**Addendum No. 1**

RE: Contract # C203875

**Tyrrell-Dare Counties (B-5936)**

Bridge #7 Over Alligator River On US-64

STATE	STATE PROJECT REFERENCE NO.	SHEET NO.	TOTAL SHEETS
N.C.	B-5936	1	
STATE PROJ. NO.	F.A. PROJ. NO.	DESCRIPTION	
46478.1.1	—	P.E.	
46478.3.1	—	CONSTR.

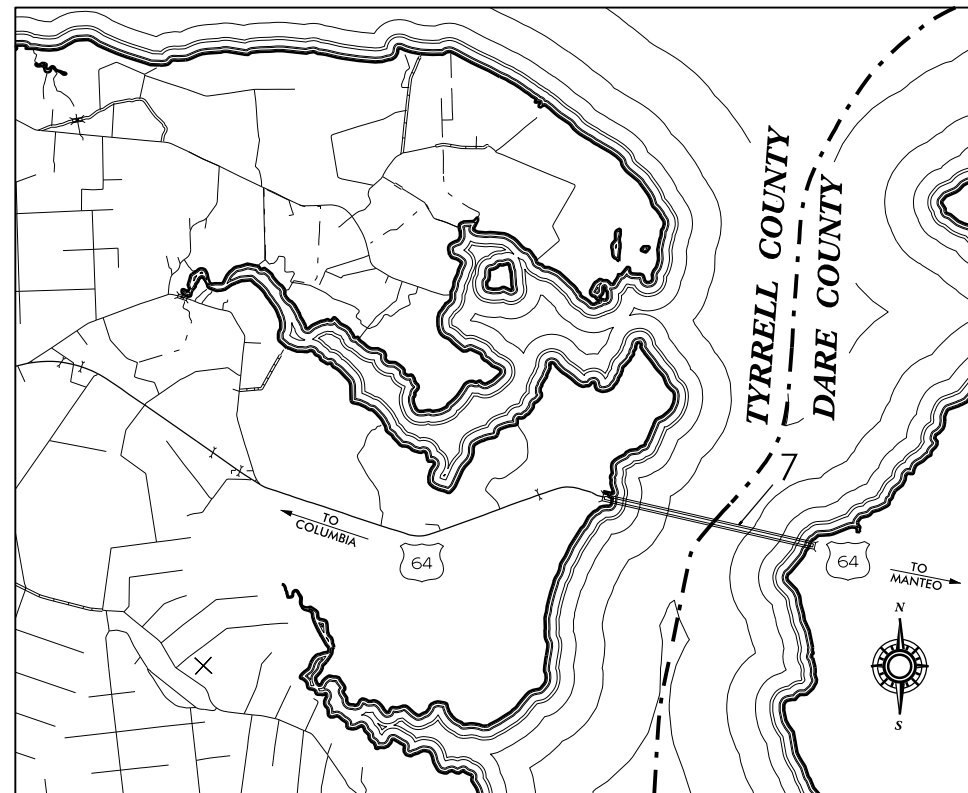
Sheet No.	Revisions
Title Sheet	Revised to change the Letting Date to November 15, 2016
